CITY OF ALBUQUERQUE

December 21, 2017

**RE: Family Dollar
1400 Gibson Blvd SE
Grading Plan
Engineers Stamp Date: 12/12/17 (L15D049)**

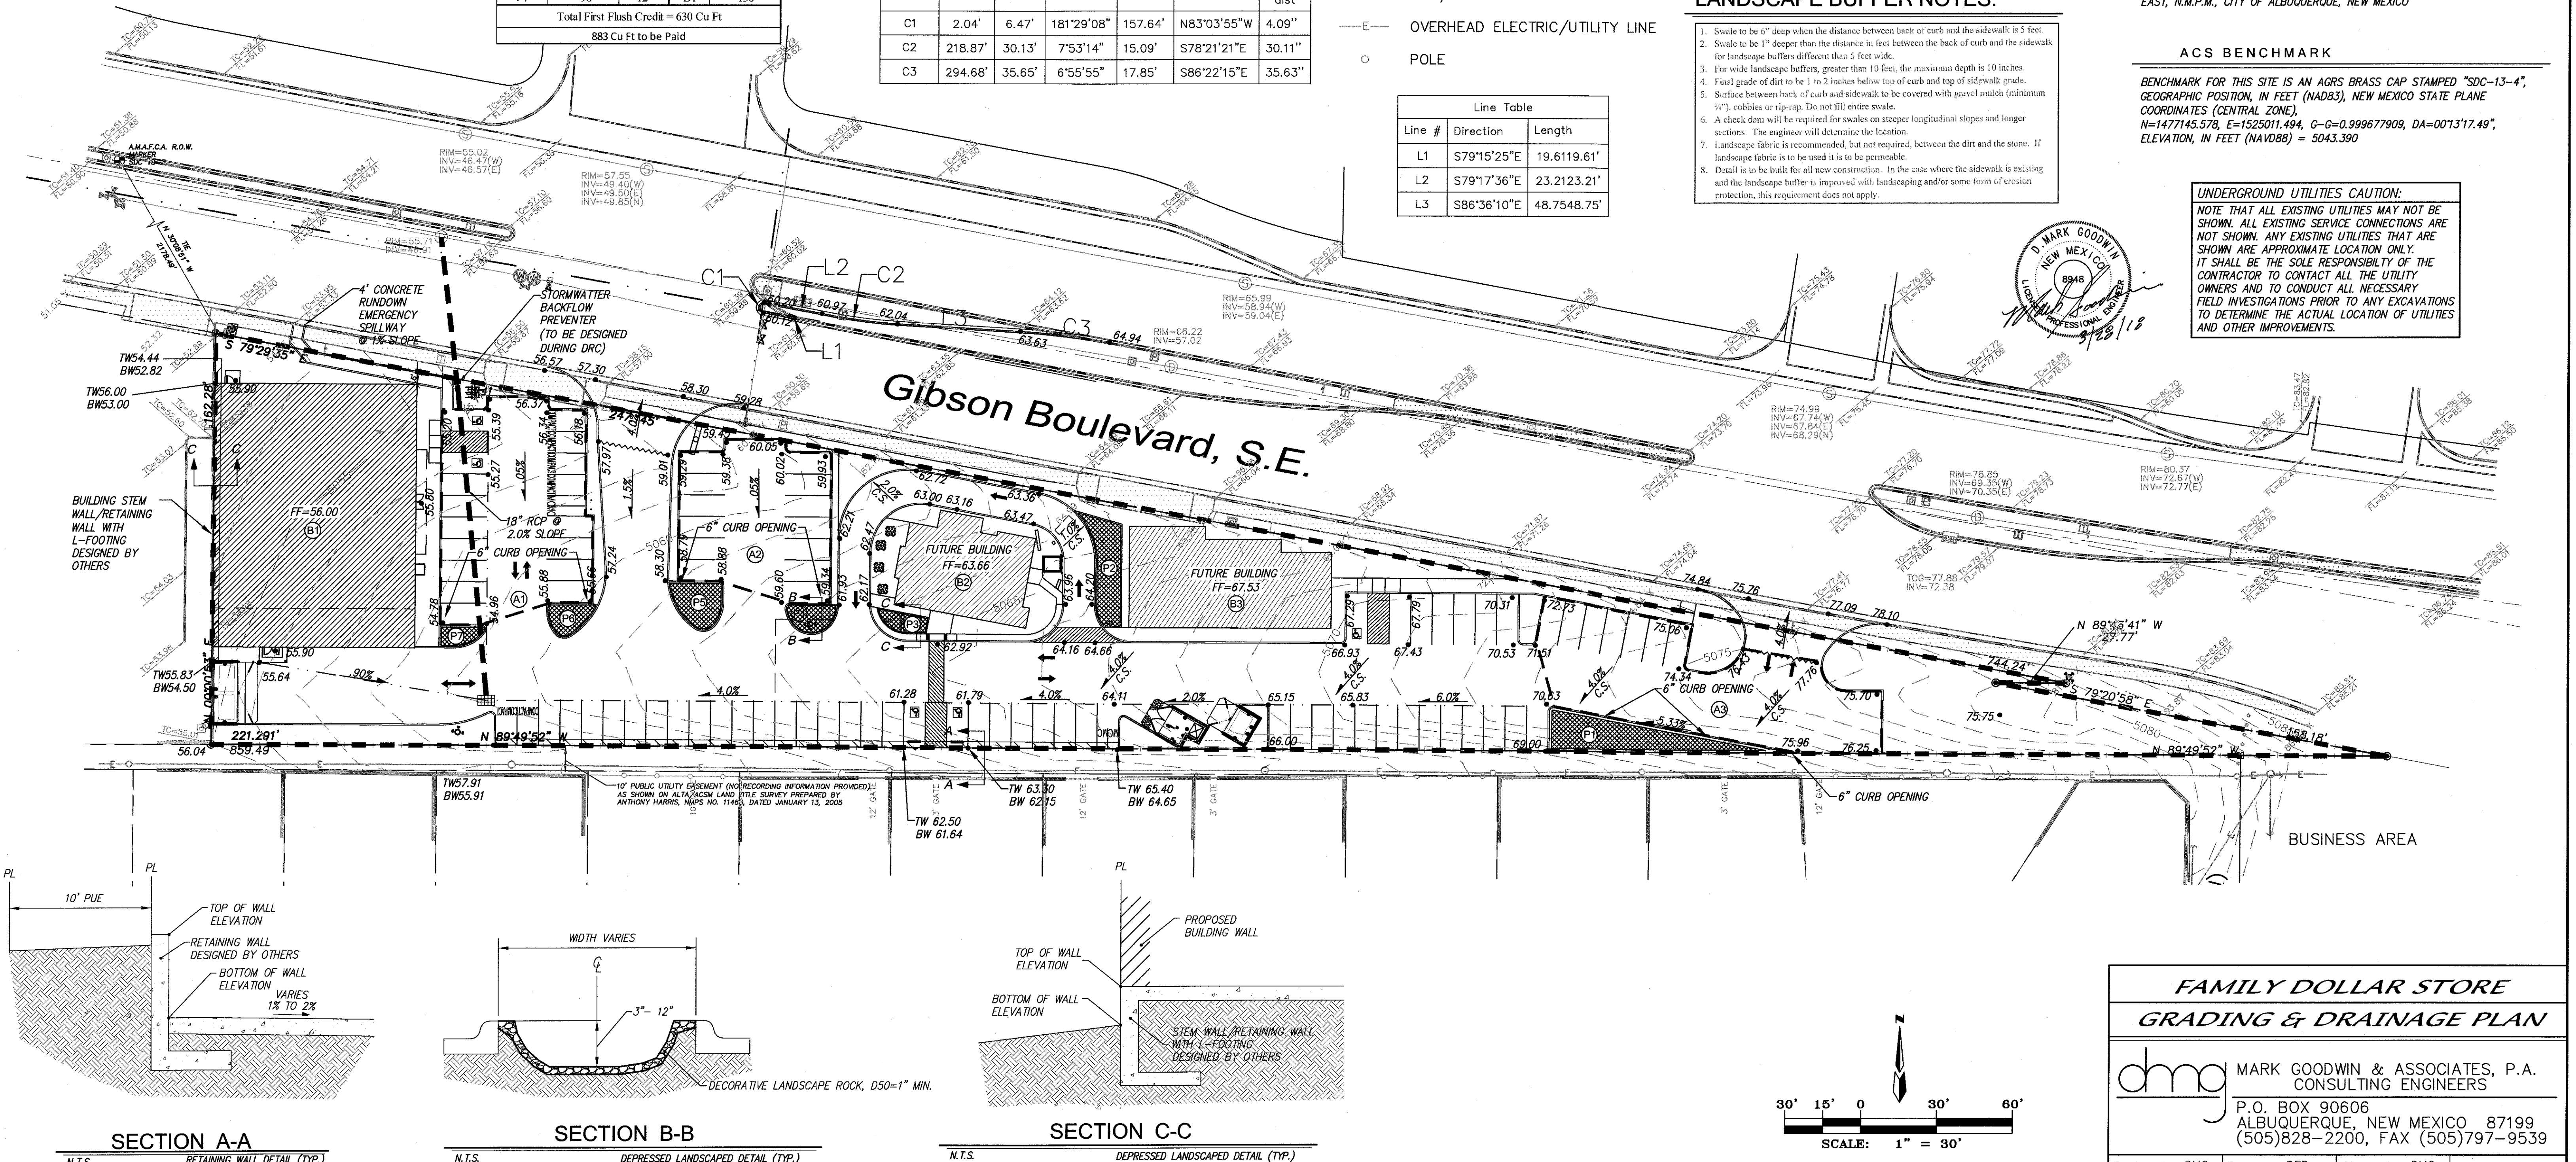
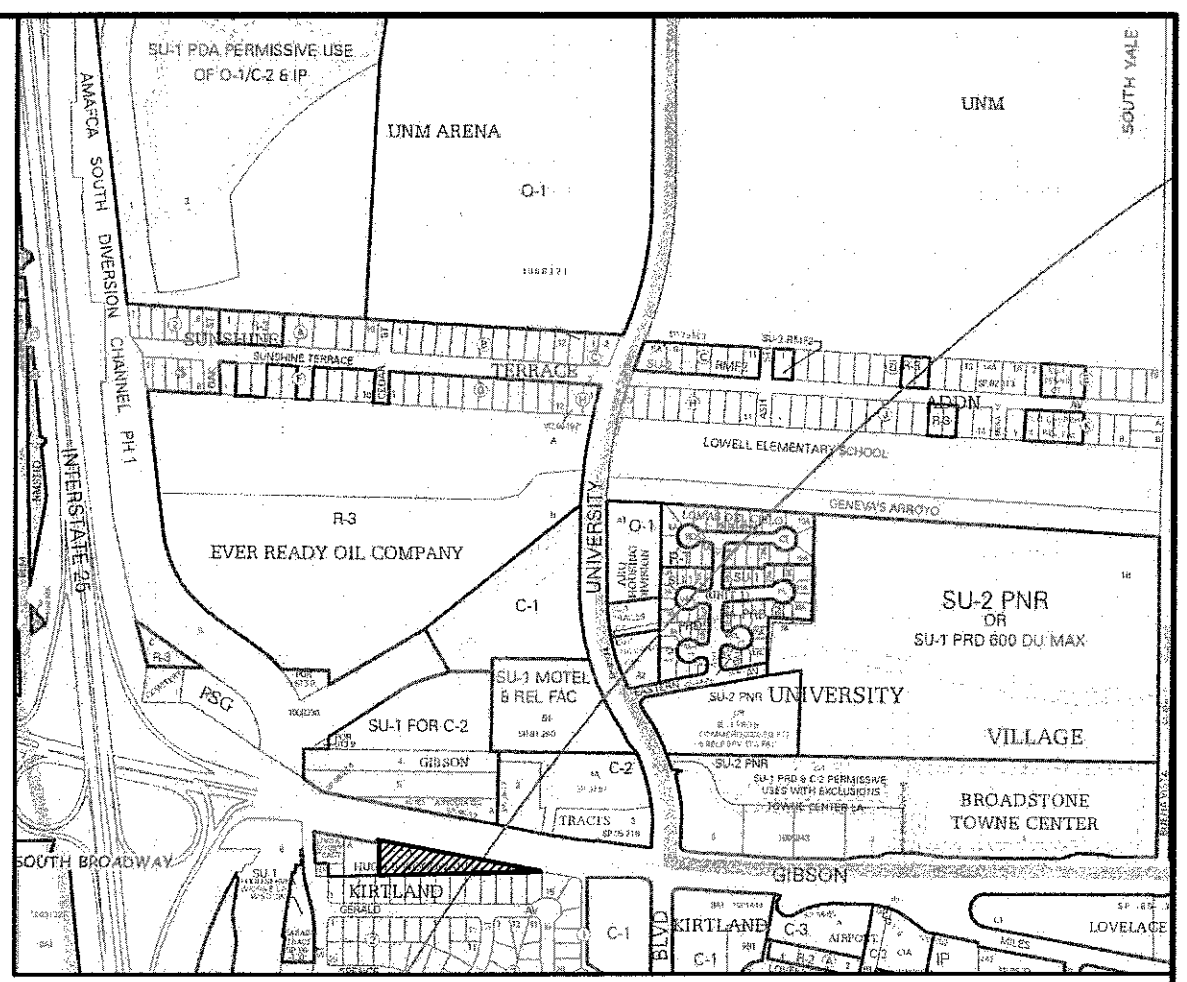
1. The property lines do not appear to match the Bernalillo County parcels. Please provide a current ALTA Survey and clearly show property lines on the grading plan.

2. This site must demonstrate downstream capacity before any increase in runoff can be approved.
3. Stormwater quality ponds need to be located where they can intercept all flows from the impervious areas.

4. It is unclear what is being built with this project. Is all of the paving being completed with this phase, leaving only building pads for phase 2? Or, is only enough paving to serve the Family Dollar being completed?

5. Work along the southern boundary needs to be clarified. Extend the section view to show existing and proposed grades and the existing walls. If a new wall straddling the property line is required, written permission from the adjoining landowners will need to be obtained.

6. The stormwater quality ponds will need private facility drainage covenants.
